Agency Submissions

Item	Issue	Response
Department of Planning and Environment		
1	Traffic and parking Provide a copy of the Parking Demand Study and Traffic Assessment (October 2017) referenced in the Traffic Impact Assessment.	The parking study and TIA for the carpark (Oct 2017) is provided at Appendix C .
2	Correct inconsistencies in the number of parking spaces to be removed / provided in the proposed development as set out in the Environmental Impact Statement (366 spaces to be removed and 205 spaces to be provided) and Traffic Impact Assessment (447 spaces to be removed and 201 spaces to be provided).	We confirm the numerics in the EIS are incorrect and the proposal will remove 447 spaces and will introduce 201 car parking spaces as stated in the Traffic Report. It is noted that under separate applications a multi-storey car park and several at-grade car parks are being delivered across the Hospital campus that will increase car park provision (refer to Section 2.2 of the ESI). Inclusive of these non-SSD works, the Hospital will increase parking provision by 834 spaces (Refer to Section 7.3 of the Traffic Report at Appendix H of the EIS).

DEPARTMENTAL AREA
LIFT - PUBLIC
LIFT - PATIENT/STAFF/SERVICES
LIFT - TRAUMA

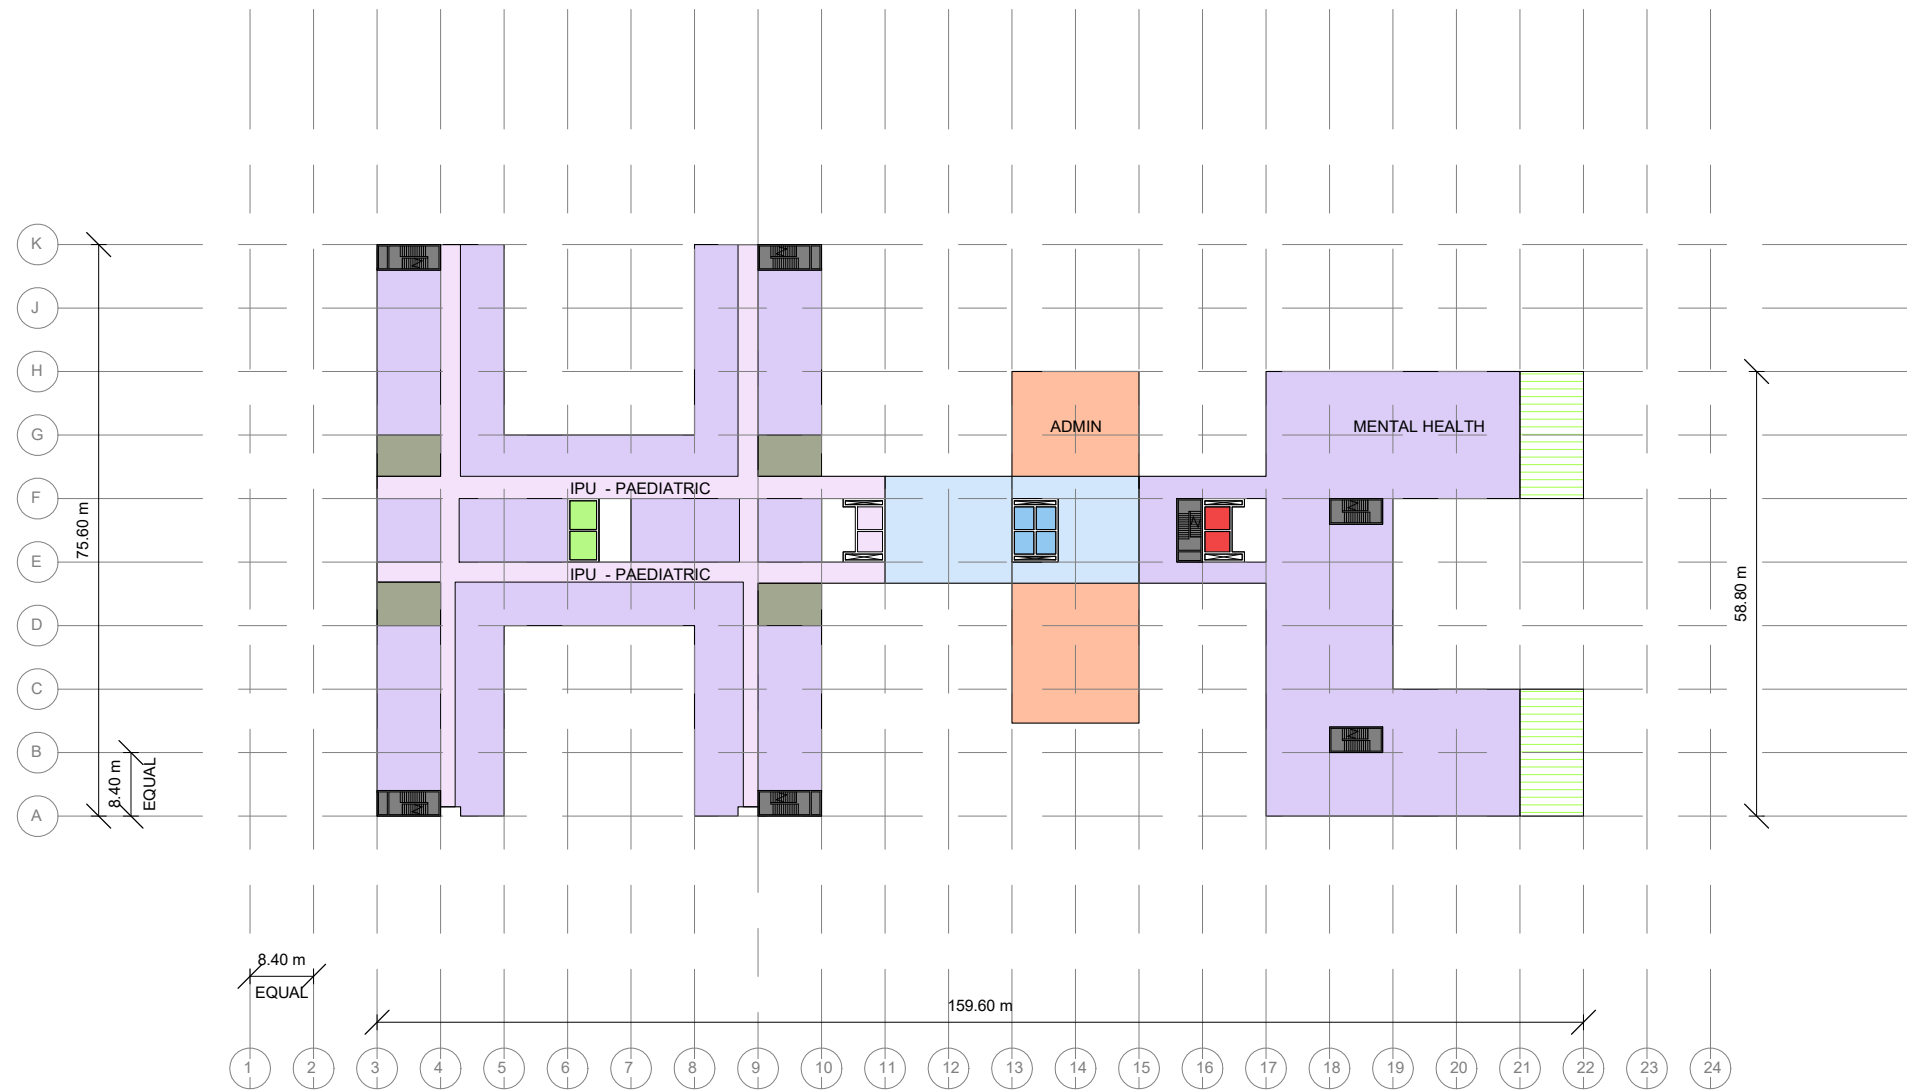
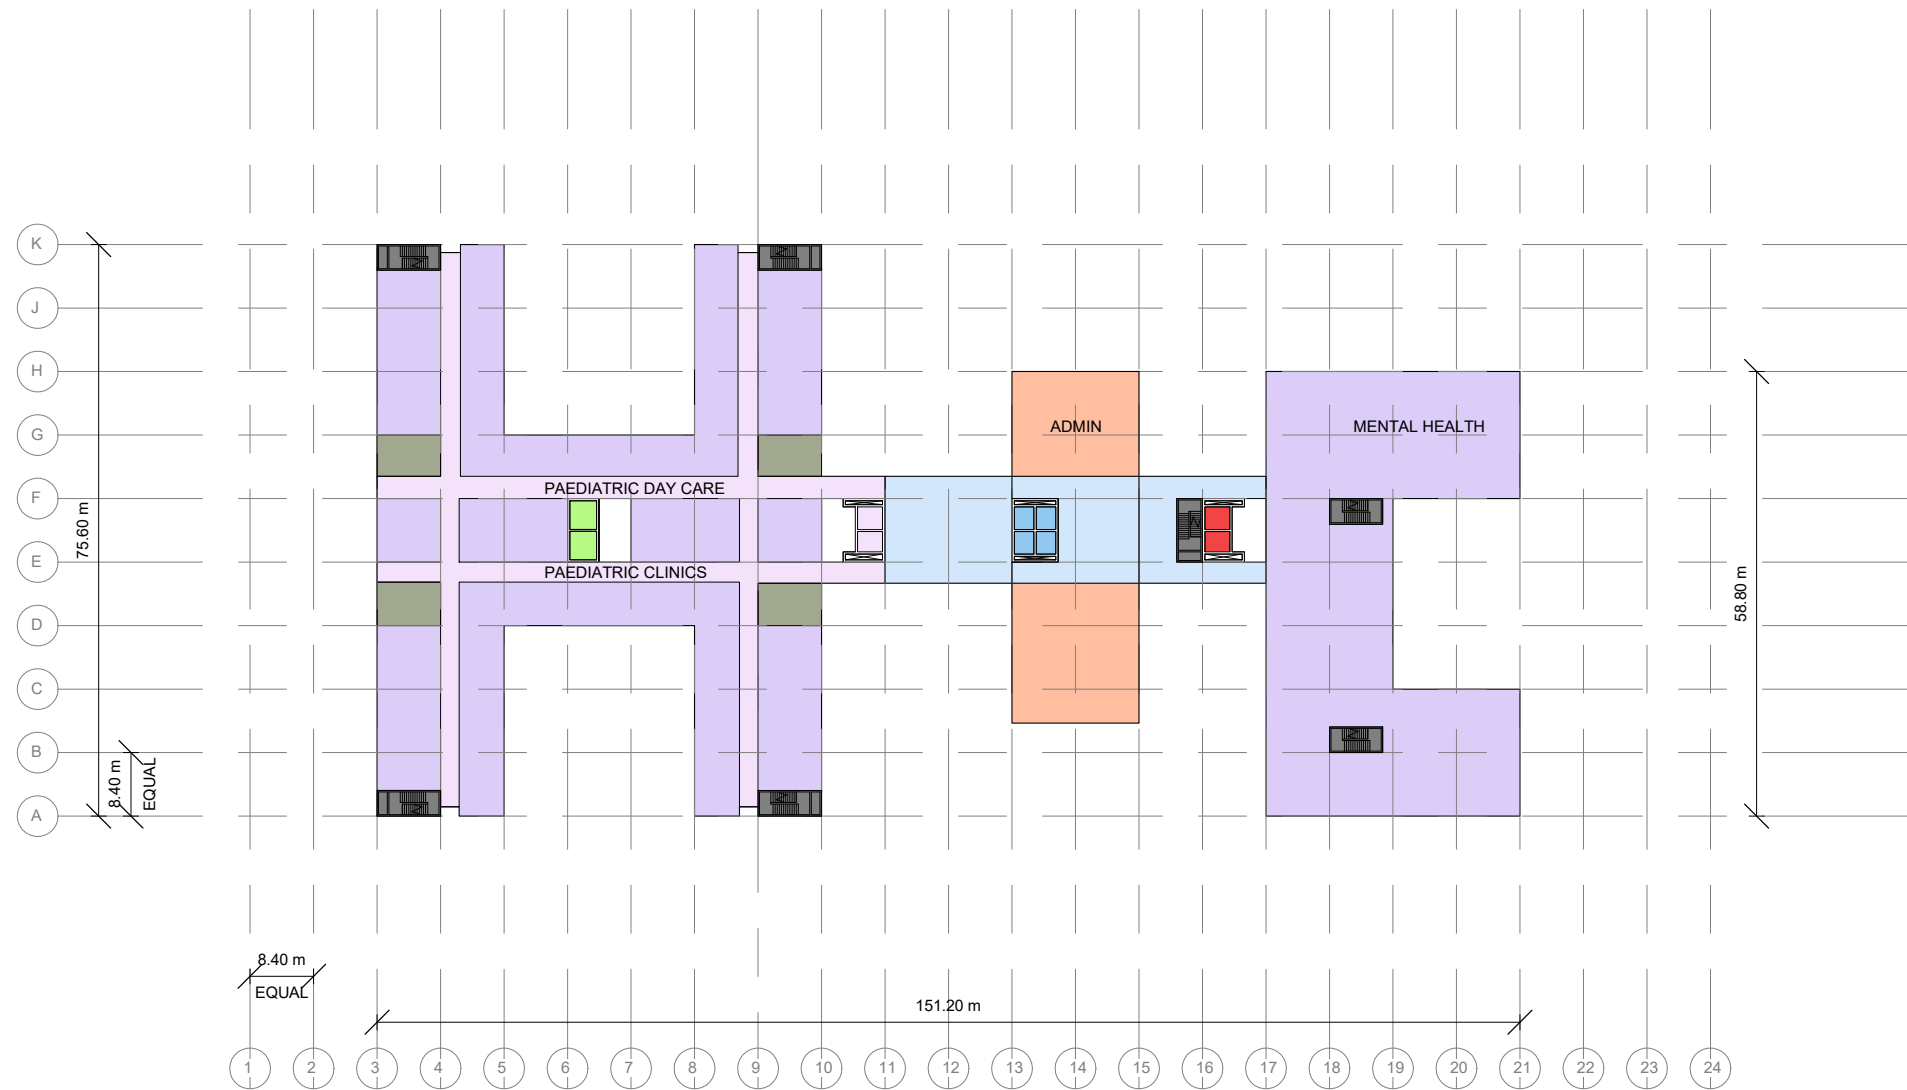
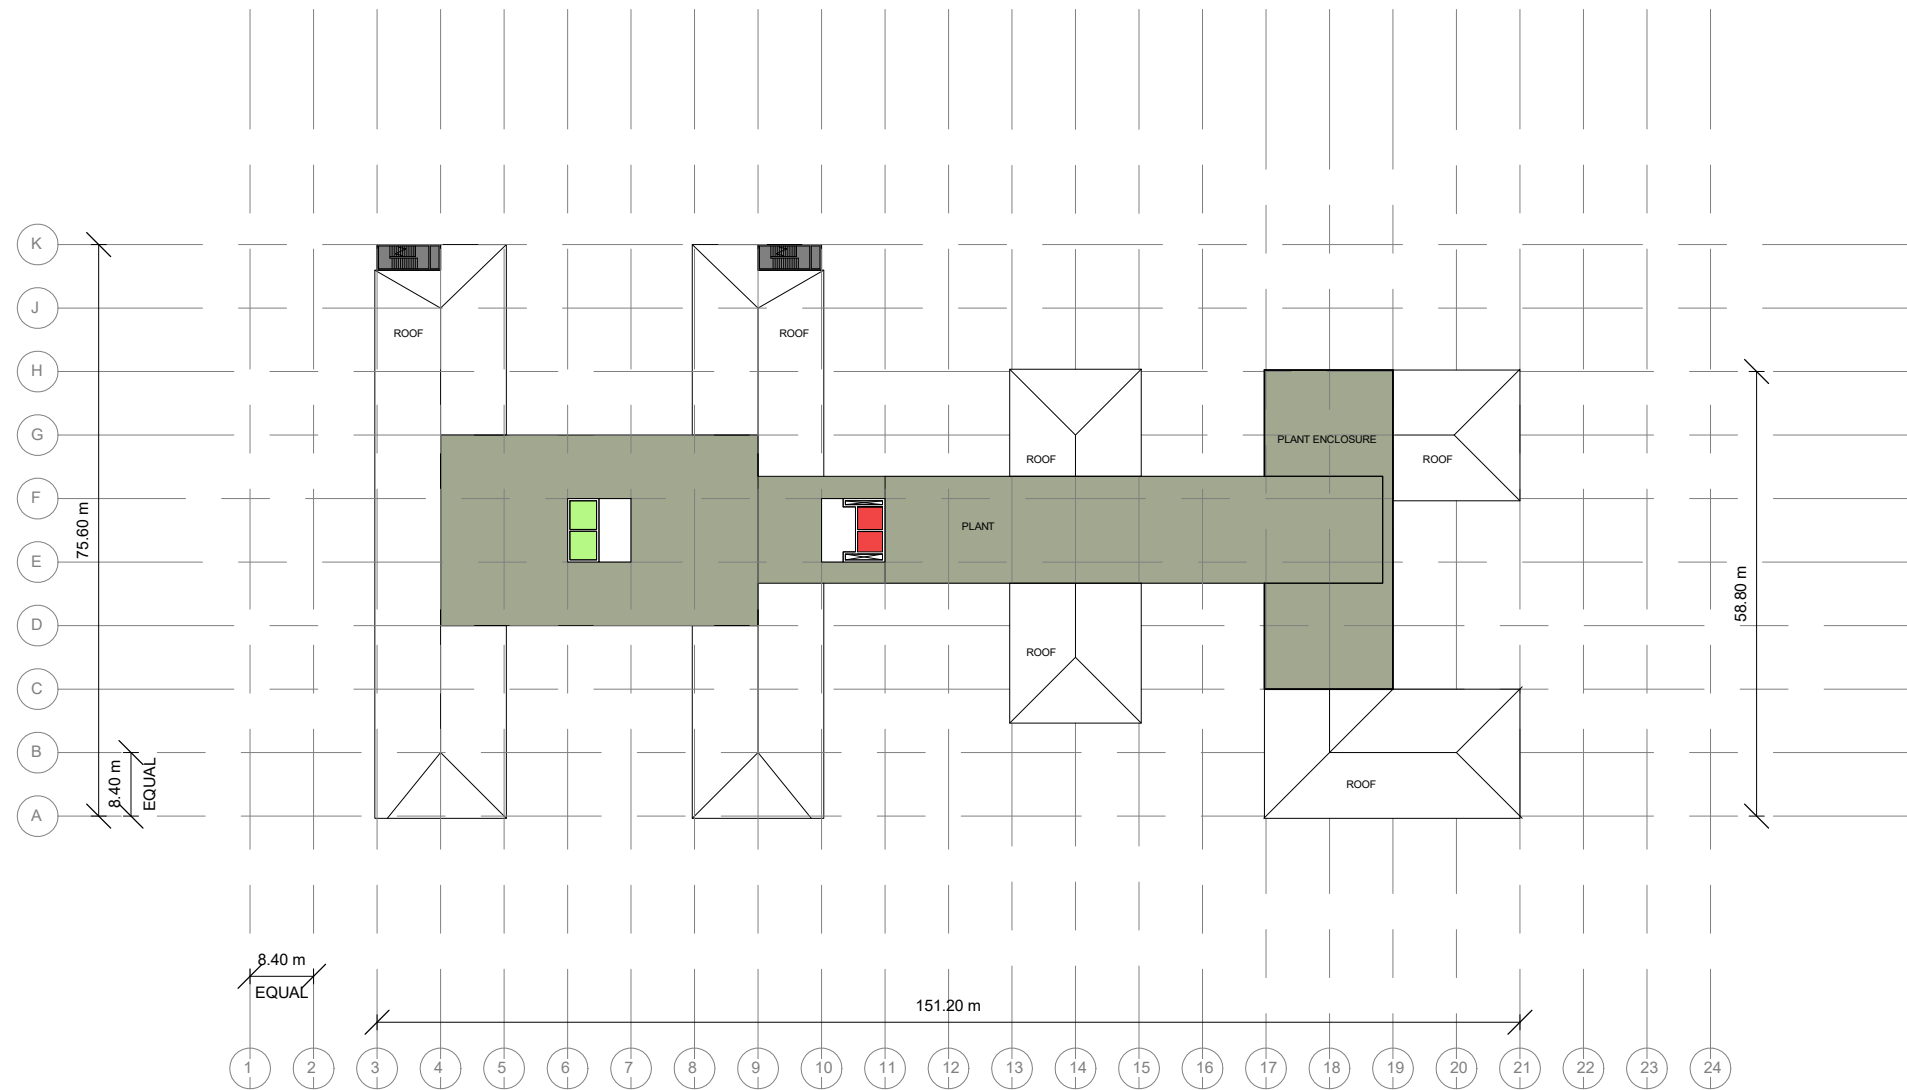
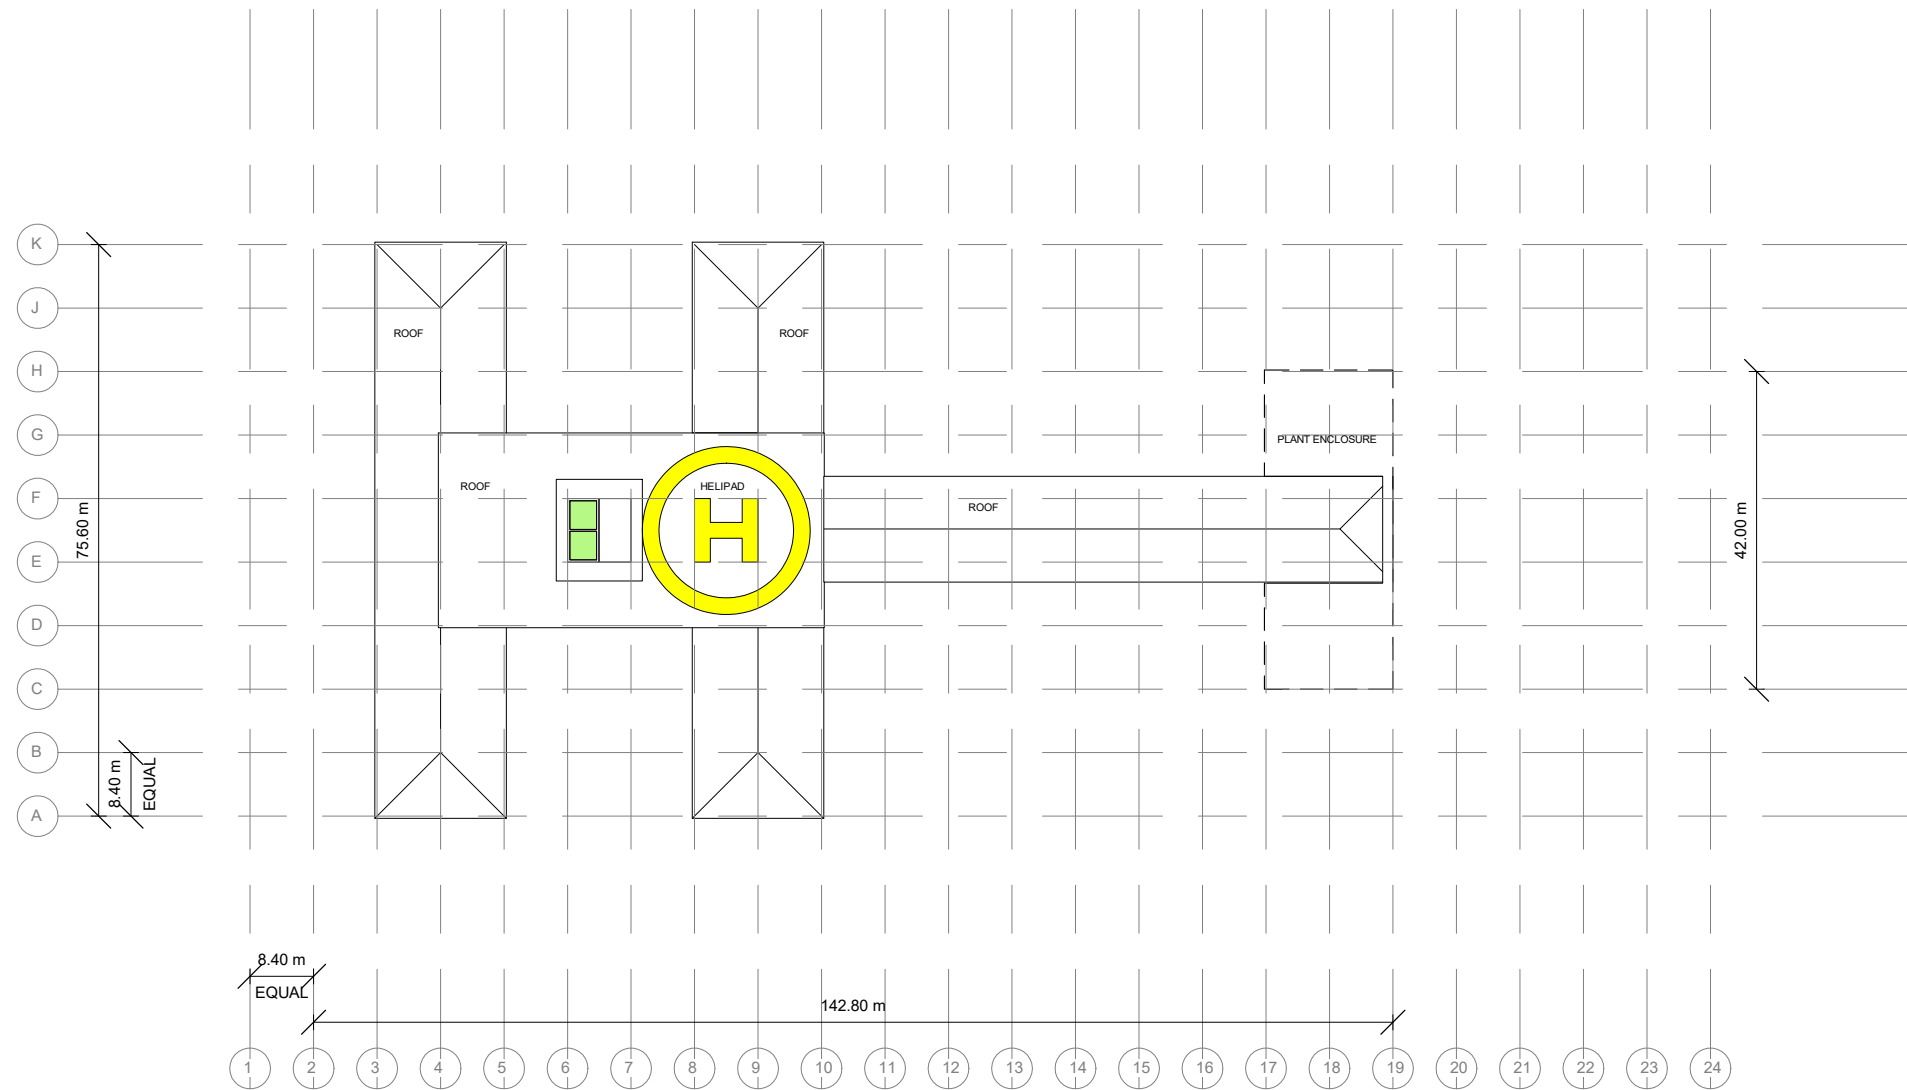
46	<p>Radiation control</p> <p>1. The proponent be required to clarify whether –</p> <ul style="list-style-type: none"> (a) the planned radio-therapy and brachy therapy are included as part of Stage 2; (b) nuclear medicine facilities shown on drawing 'SSD-03-000' are existing or part of Stage 2 refurbishment of building A; (c) diagnostic imaging facilities are to be located in the clinical services building; and (d) diagnostic imaging facilities are to continue to be provided in Building A. <p>2. The proponent be required to ensure shielding of 'regulated material', including diagnostic imaging equipment is assessed and calculated in accordance with the EPA's guidance material provided in "Radiation Guideline 7 - Radiation shielding design assessment and verification requirements".</p>	<p>The following comments address queries 1-3.</p> <p>1.</p> <ul style="list-style-type: none"> a) Yes and additional linac bunker is part of the radiotherapy expansion b) Nuclear medicine facilities are part of the refurbishment of Building A and not part of this SSD application. c) A new satellite imaging department will be located in the Emergency Department of the new CSB. d) The main imaging department will be expanded in its existing location in building A (not part of this application). <p>2. A radiation shielding design consultant has been engaged for the project.</p> <p>3. This comment is noted</p>
